ENG-PUDSP21006-R2-PUDSP.pdf Markup Summary

# 1 PLANTING PLAN

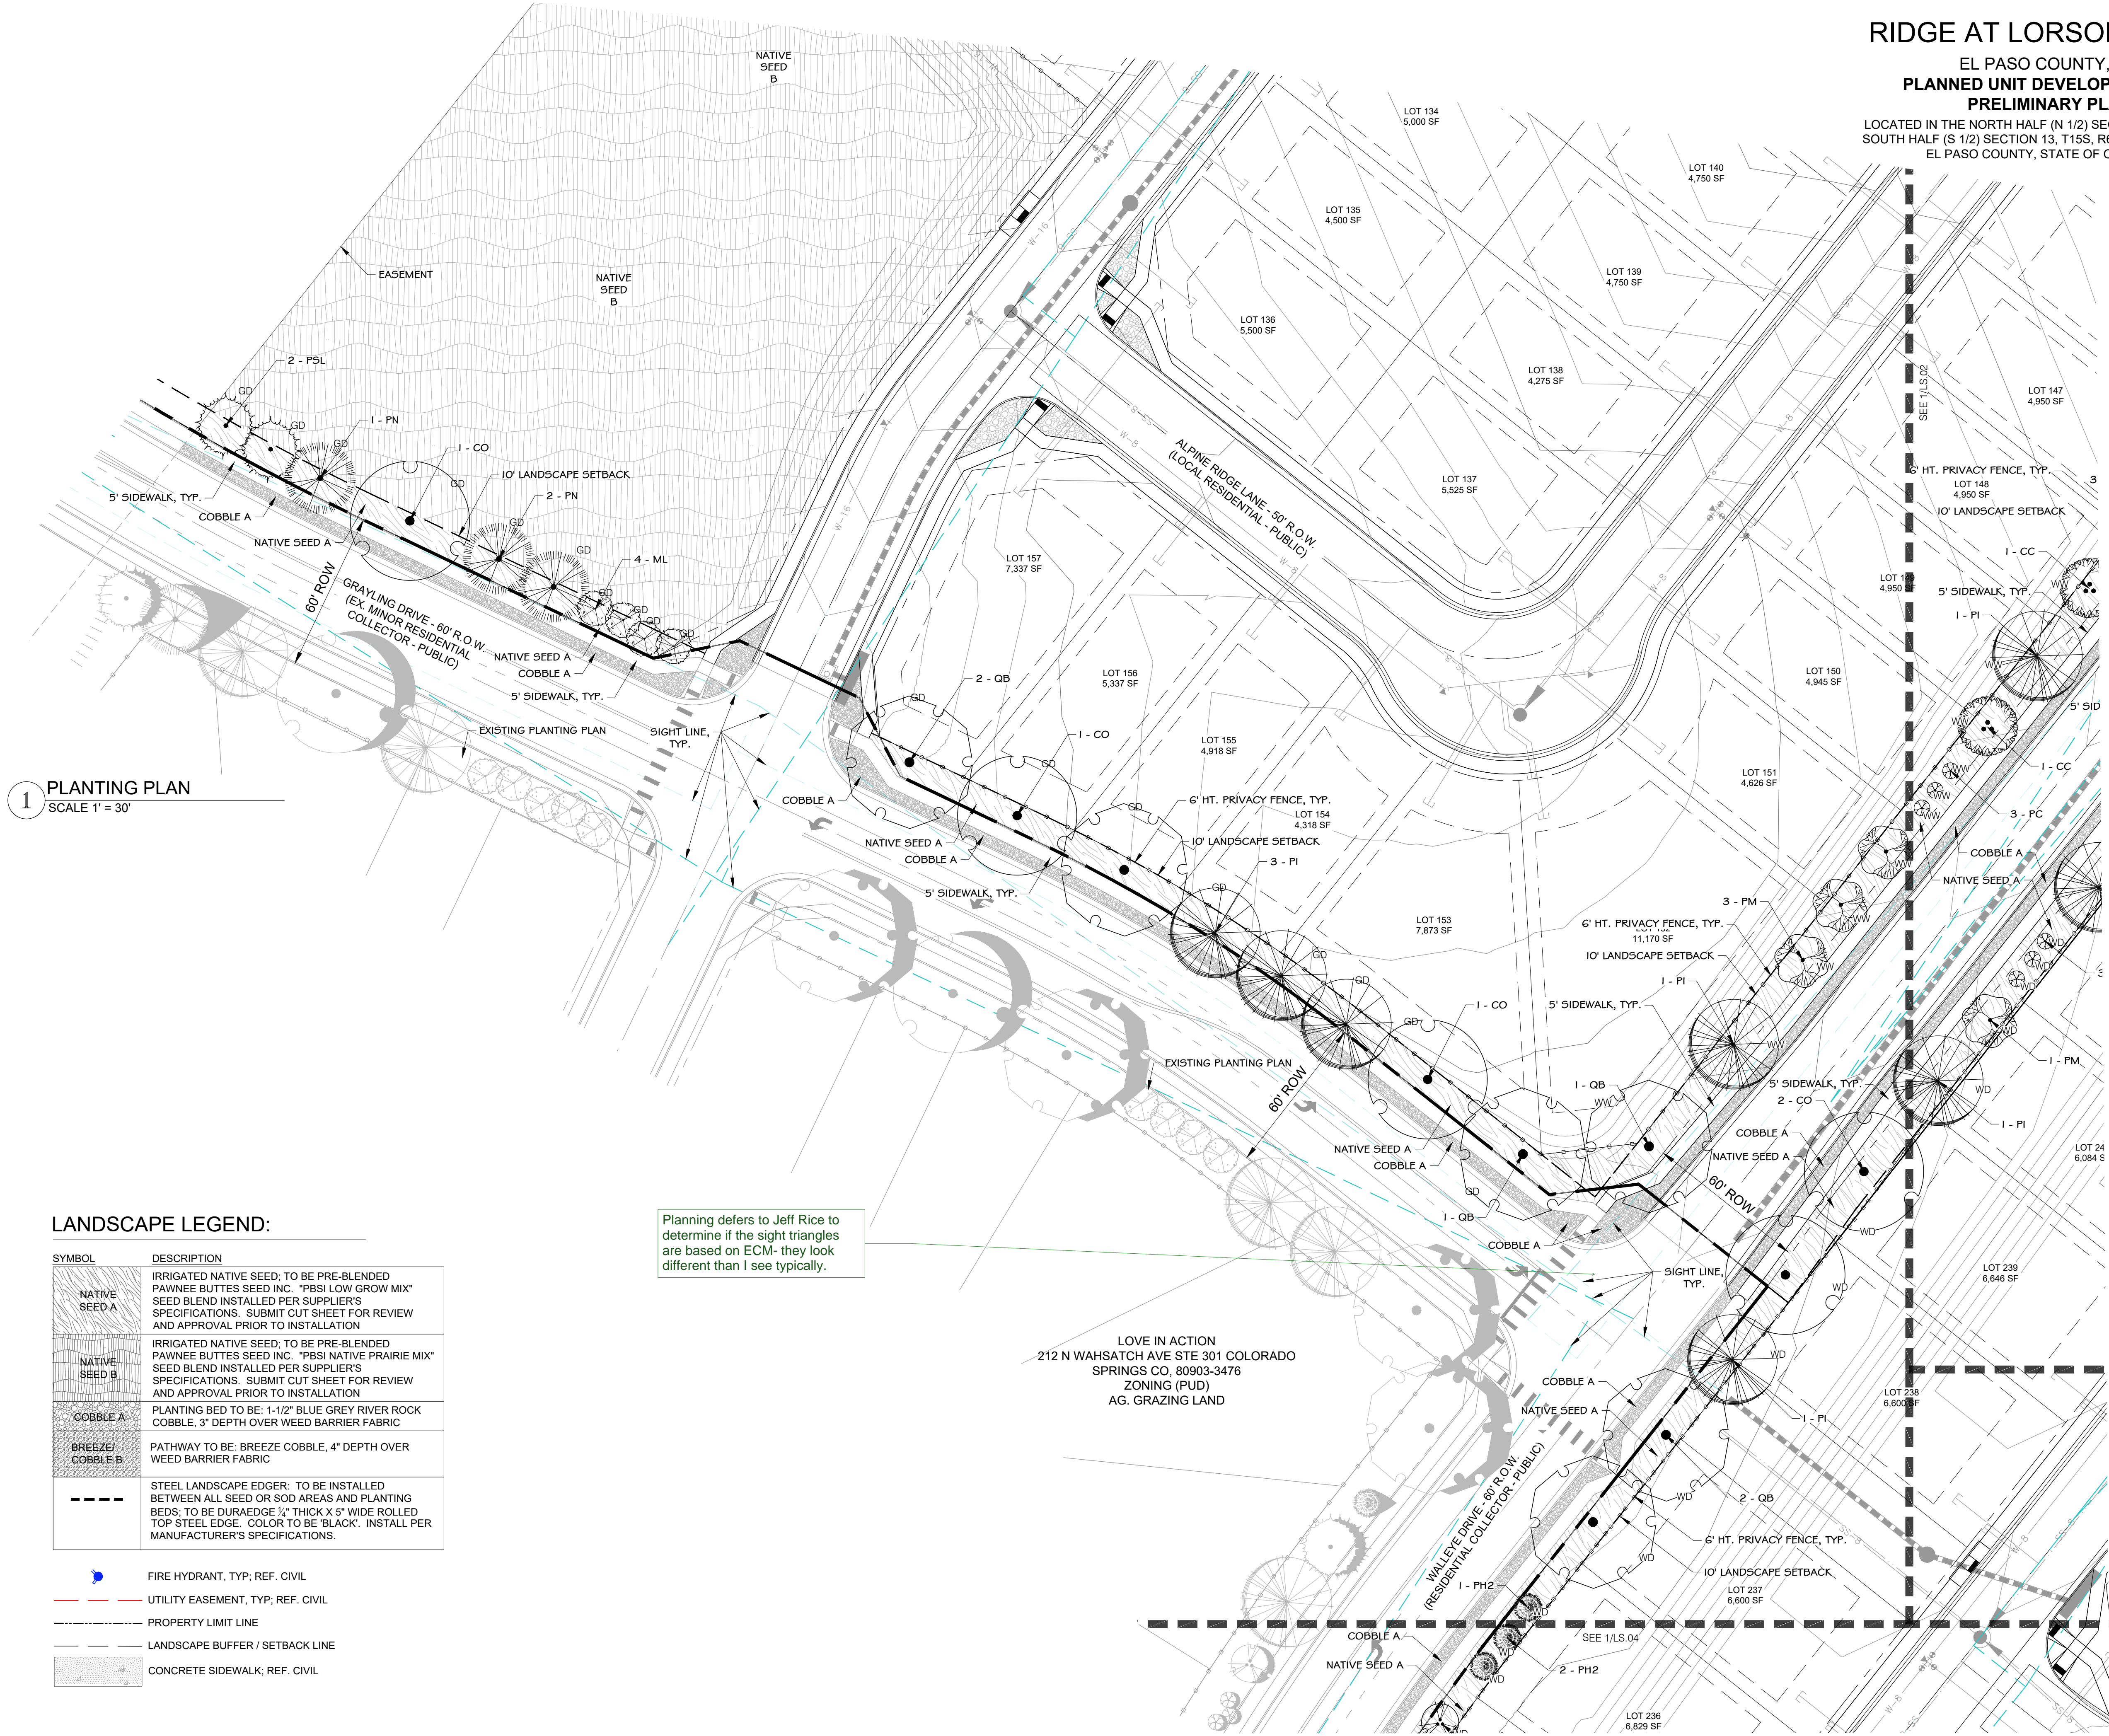
Planning defers to Jeff Rice to determine if the sight triangles are based on ECM- they look different than I see typically.

Add sight distance to landscape plan stop controlled intersections please, verify plantings are less than 3.5' and more than 8' canopy

trees should be made to have canopy over 8' on this curve
